Morecambe Offshore Windfarm: Generation Assets Examination Documents

The Applicant's Response to Spirit Energy Deadline 1 Submissions Appendix A: The Applicant's Comments on Spirit Energy and Harbour Energy Aviation Access Study Report

Document Reference: 9.35.1

Figure 6
Entry and Positioning onto FAS into Wind in a VFR HPZf via HPZc

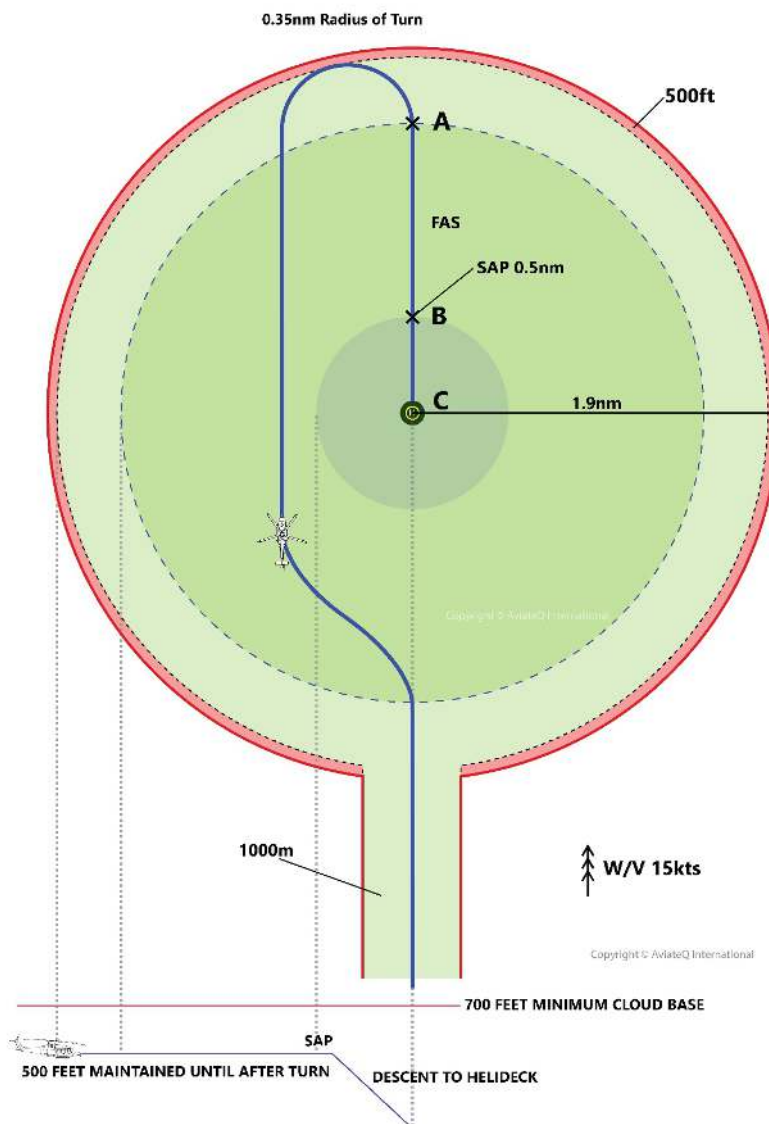
| Comment ID | AviateQ Text | Applicant's Comment |
|------------|---------------------------------------------------------------------------------------------------------------------------------------------------------------------------------------------------------------------------------------------------------------------------------------------------------------------------------------------------------------|---------------------------------------------------------------------------------------------------------------------------------------------------------------------------------------------------------------------------------------------------------------------------------------------------------------------------------------------------|
| 4.3.d | d) The Final Approach Sector (FAS) leading up to the Stabilised Approach Point (SAP) has been set at 1nm for standardisation although some pilots may elect, due to wind conditions, to intercept the FAS at a point closer than 1nm. | The HeliOffshore Stabilised Approach Point is 0.5nm, Bond Helicopters use 0.75nm. The distance of 1.26nm was agreed in the Dudgeon Extension DCO following consultation with Bond Helicopters. A Stabilised Approach Point of 1nm for day VMC is excessive and not supported by industry guidance and draft CAP 764 paragraph 5.24.c ³ |

| Comment ID | AviateQ Text | Applicant's Comment |
|------------|-----------------------------------------------------------------------------------------------------------------------------------------------------------------------------------------------------------------------------------------------------------------------------------------------------------------------------------------------------------------------------------------------------------------------------------------------------------------------------------------------|-----------------------------------------------------------------------------------------------------------------------------------------------------------------------------------------------------------------------------------------------------------------------------------------------------------------------|
| 5.1 | 5. The Stabilised Approach Point (SAP) shall be 0.5nm from the destination helideck. | The distance of 0.5nm is agreed; this is consistent with current industry guidance and best practice. In their paragraph 4.3 (d) |

Figure 7A

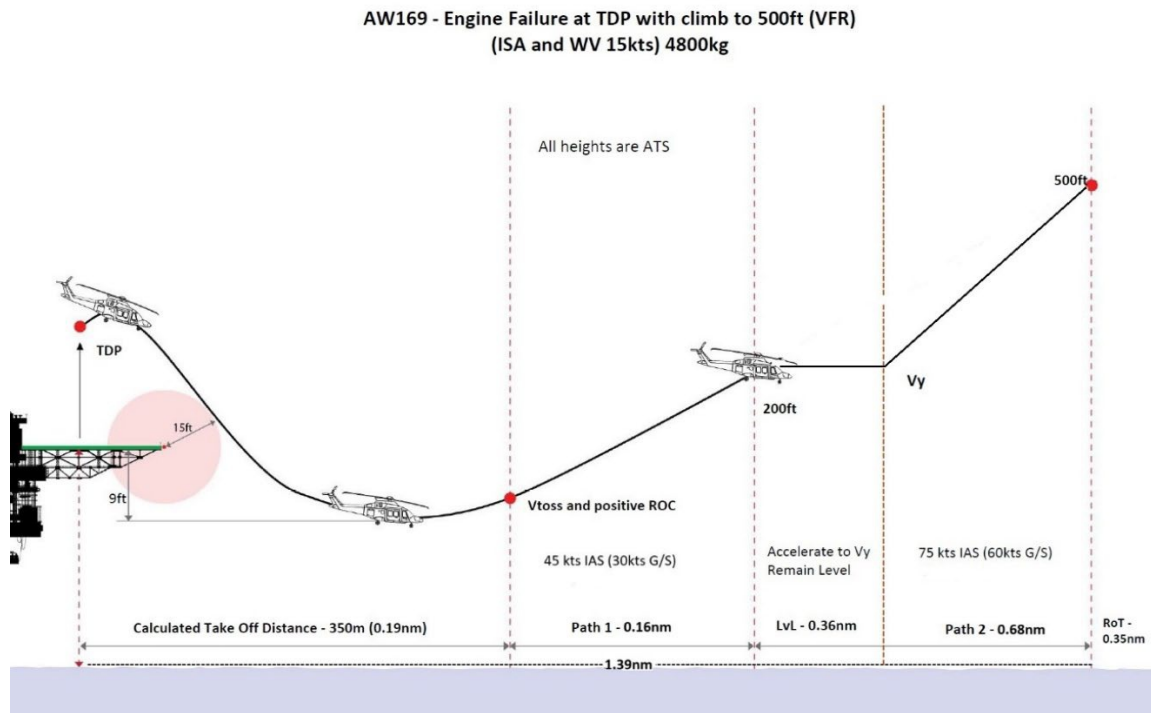
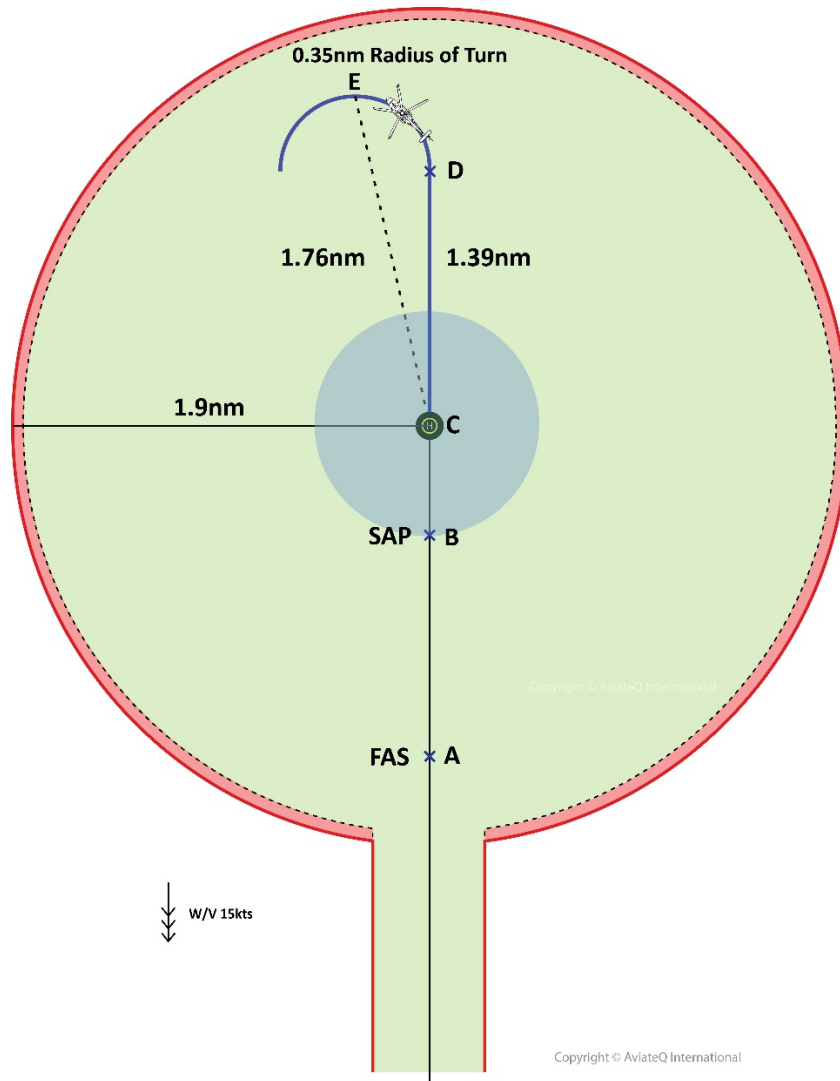
| Comment ID | AviateQ Text | Applicant's Comment |
|------------|----------------------------------------------------------------------------------------------------------------------------------------------------------------------------------------------------------------------------------------------------------------------------------------------------------|-----------------------------------------------------------------------------------------------------------------------------------------------------------------------------------------------------------------------------------------------------------------------------------------------------------------------------------------------------------------------------------------------------------------------------------------------------------------------------------------------------------------------------------------------------------------------------------------------------------------------|
| 4.5.iii | VFR - Engine failure after take-off from a facility with OEI climb to 500ft followed by a Rate One turn. (Section 8.3) | The HAR applies a climb to 500ft above sea level before turning; this height above sea level has previously been agreed with the helicopter operators for other projects. The AviateQ Report applies a climb to 500ft above helideck height which results in a different OEI take-off distance depending on the helideck height. In the case of the South Morecambe Platform this will require a climb to 684 ft for the CPC-1 helideck (500ft + height of the helideck, 184ft) whilst a take-off from the DP-1 helideck, at the other end of the South Morecambe platform, will only require a climb to 594ft (500ft |

| Comment ID | AviateQ Text | Applicant's Comment |
|------------|-------------------------------------------------------------------------------------------------------------------------------------------------------------------------------------------------------------------------------------------------------------------------------------------------------------------------------------------------------------------------------------------------------------------------------------|-------------------------------------------------------------------------------------------------------------------------------------------------------------------------------------------------------------------------------------------------------------------------------------------------------------------------------------------------------------------------------------------------------------------------------------------------------------------------------------------------------------------------------------------------------------------------------------------------------------------------------------------------------------------------------------------------------------------------------------------------------------------------------------------------------------|
| | | <p>+ height of the helideck, 94ft). Furthermore, as the current day VMC limits permit a cloud base as low as 600ft above sea level, a climb from CPC-1 to 684ft would result in a climb into IMC. Even applying the proposed CAA rule change of a minimum cloud base of 700ft would result in the helicopter climbing within 100ft of the cloud base and so being IMC – see the AviateQ Report 4.3 c) that states: <i>“when remaining clear of cloud and in sight of the surface in accordance with VFR requirements, the minimum vertical distance between the helicopter and the cloud base has been set to 100ft”</i>.</p> <p>For consistency with other projects, and in accordance with standard practice, all heights used in the report should be above sea level and not above helideck height.</p> |

Figure 10A

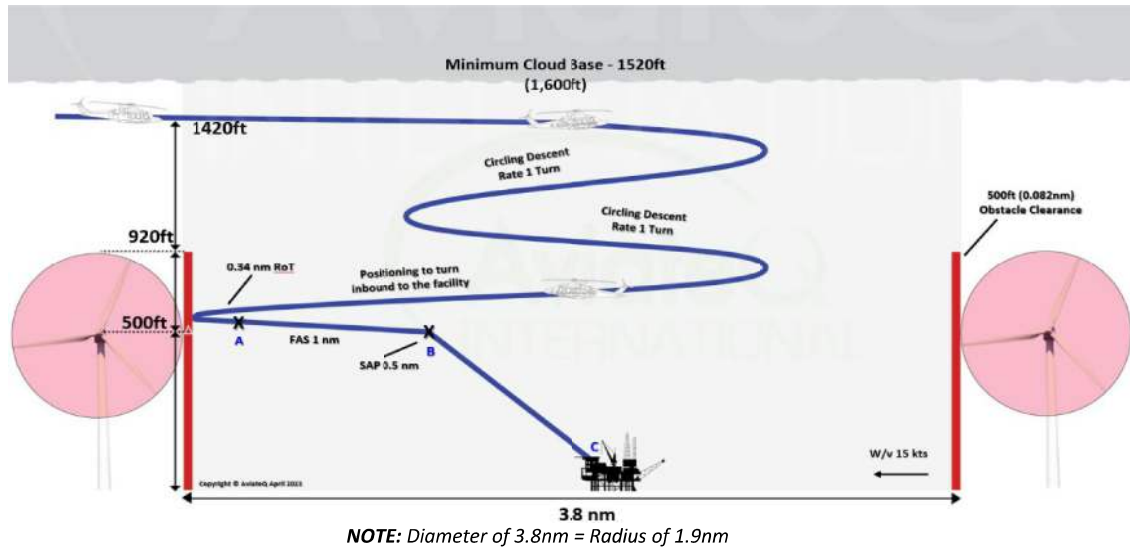
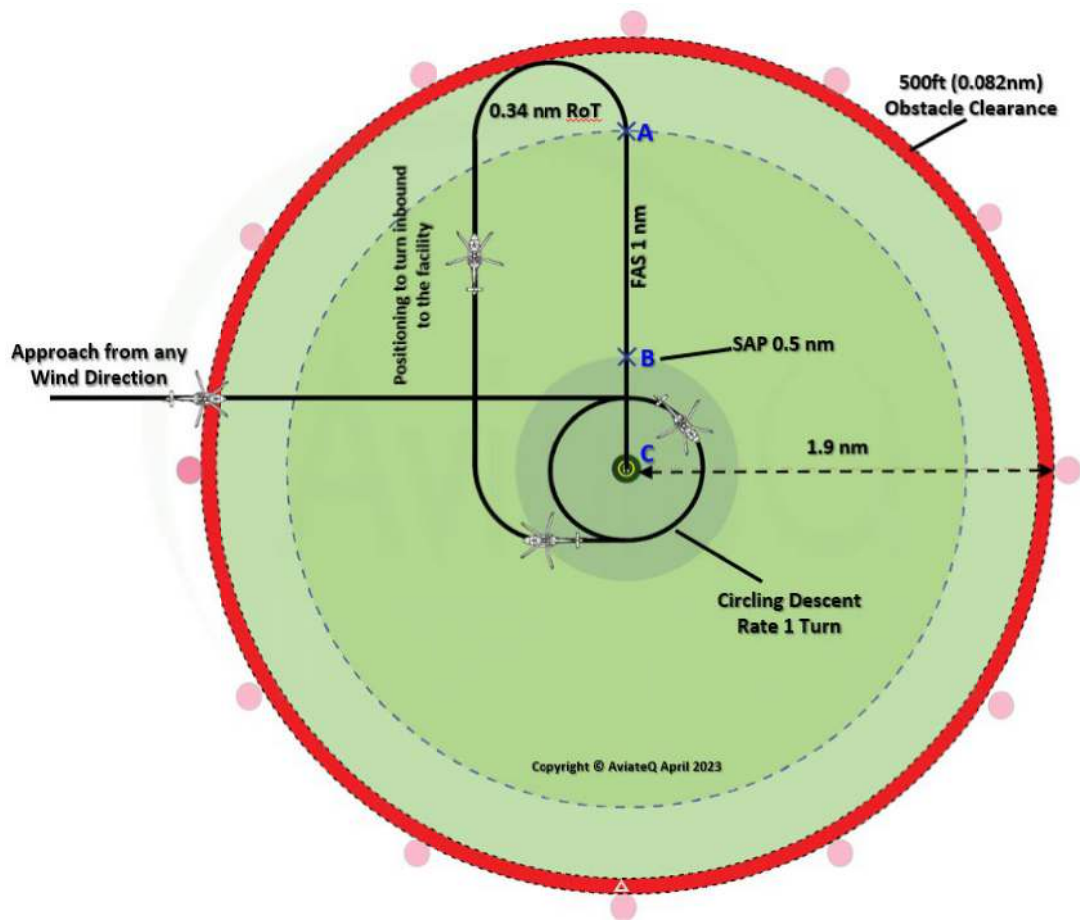
| Comment ID | AviateQ Text | Applicant's Comment |
|------------|-------------------------------------------------------------------------------------------------------------------------------------------------------------------------------------------------------------------------------------------------------------------------------------------------------------------------------------------------------------------------------------------------------------------------------------|-------------------------------------------------------------------------------------------------------------------------------------------------------------------------------------------------------------------------------------------------------------------------------------------------------------------------------------------------------------------------------------------------------------------------------------------------------------------------------------------------------------------------------------------------------------------------------------------------------------------------------------------------------------------------------------------------------------------------------------------------------------------------------------------------------------|
| 4.5.v | VFR - Overflying a wind farm array to access a facility in the centre of a HPZf without a VFR corridor, conducting a circling descent and positioning for an approach with the wind from any direction. Additionally, following an engine failure after take-off from the facility to climb to 500ft followed by a circling climb to 1,500ft to exit the HPZf and transit on only one engine over the windfarm array. (Section 8.5) | As no helidecks are located inside the wind farm, it is not understood why this profile is required. A spiral descent does not meet the standard stabilised approach criteria and so should not be used. |
